DARLING HARBOUR LIVE (DHL)
THE HAYMARKET
SUPPLEMENTARY PUBLIC DOMAIN DESIGN REPORT FOR SSDA 4

JANUARY 2014

HASSELL has prepared this Supplementary Public Domain Design Report for SSDA4 in response to key issues raised by:

**PLANTING PLAN**

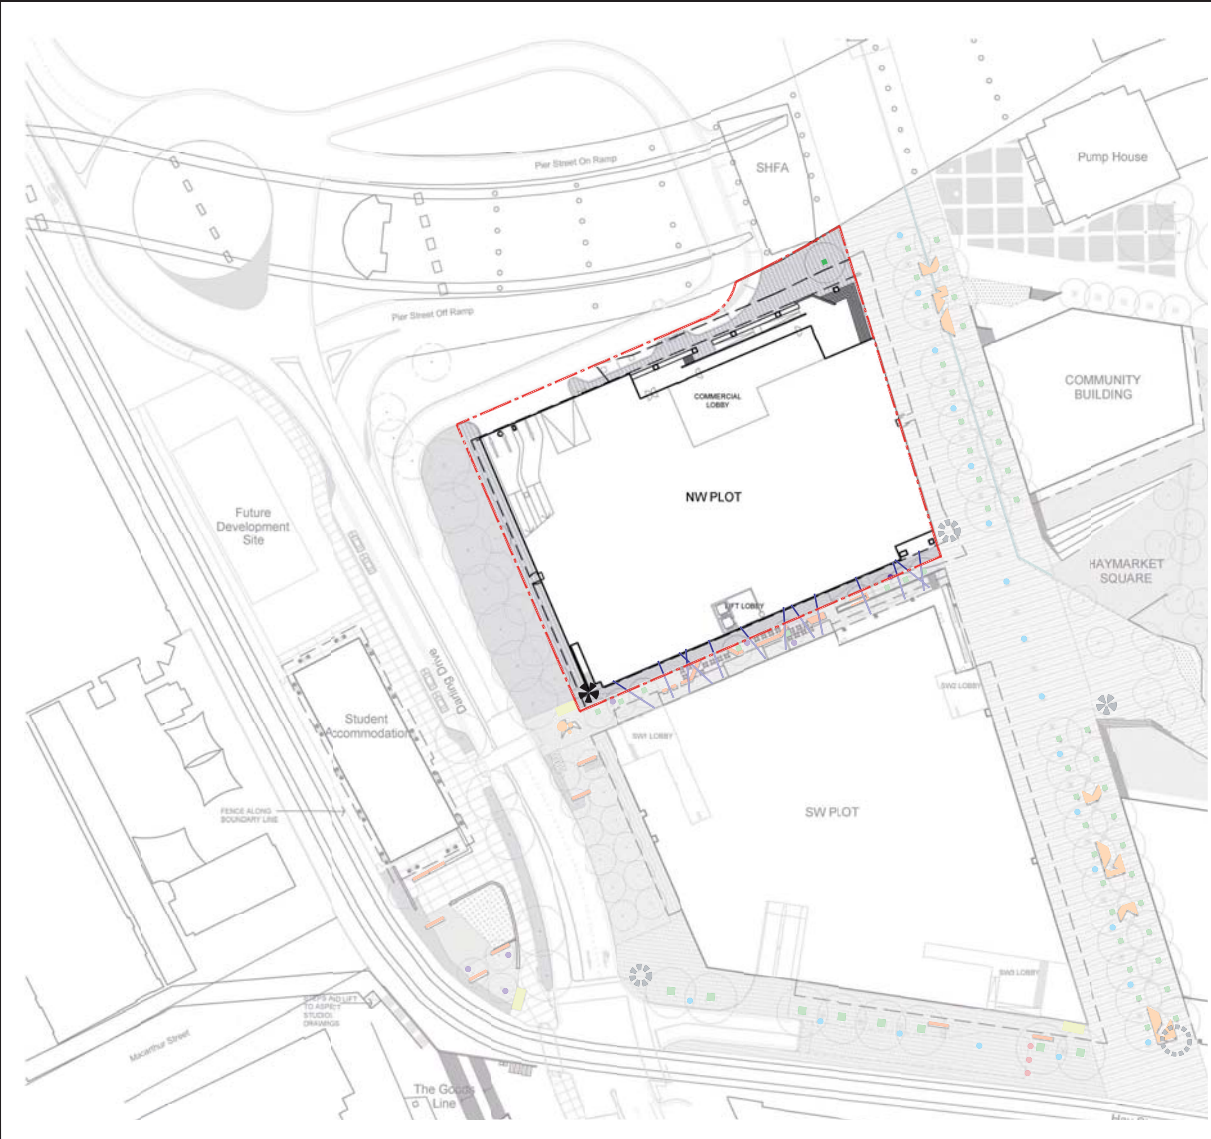
36. New tree planting along the northern frontage of the building should be included in the scope as per the DHL Concept Plan for the southern precinct. A row of *Agathis robusta* is recommended to replace the single, slow growing *Magnolia grandiflora* 'Exmouth' tree currently shown.

Where necessary, the northern façade of the building should be set back to accommodate the tree planting.

c. The Department notes that the proposed planting along the northern boundary of the NW Plot has been reduced from a row of 11 trees (as suggested within the Public Domain Concept Proposal), to a single tree located adjacent to the boulevard. Justification for the reduction is required and consideration should be given to additional tree planting in this location.

Upon further detailed design review following the CoS submission a group of *Livistona australis* is proposed in this area. The plant selection reinforces the site wide theme and reference to the historical landscape. The proposed palm grove will tie in with the language of 'gullies' throughout the site - similarly to Harbourside Place and Tumblong Place in the PPP development - and will ensure a level of consistency to unify the DHL precinct and improve the intuitive wayfinding of the area.

The CoS proposal of *Agathis robusta* is not deemed appropriate for the following reasons:

- Its height (30-50m) is of a too large scale and competes with the strength of the Boulevard avenue;
- The establishment of a regular habitus, desirable for a feature tree, is too unpredictable for this species and within this spatially restricted environment in between overpass and building; and
- It is not native to this area.

Due to realignment of the road (refer to PPP SSDA1 application), a row of trees to the Northern facade is no longer possible. The proposed *Livistona* grove will however not only provide arrival address to the precinct and North West building but also allow for through sight lines for pedestrian movement off Pier Street and allow maintenance vehicle access around and under (refer figure 3.1.1.).
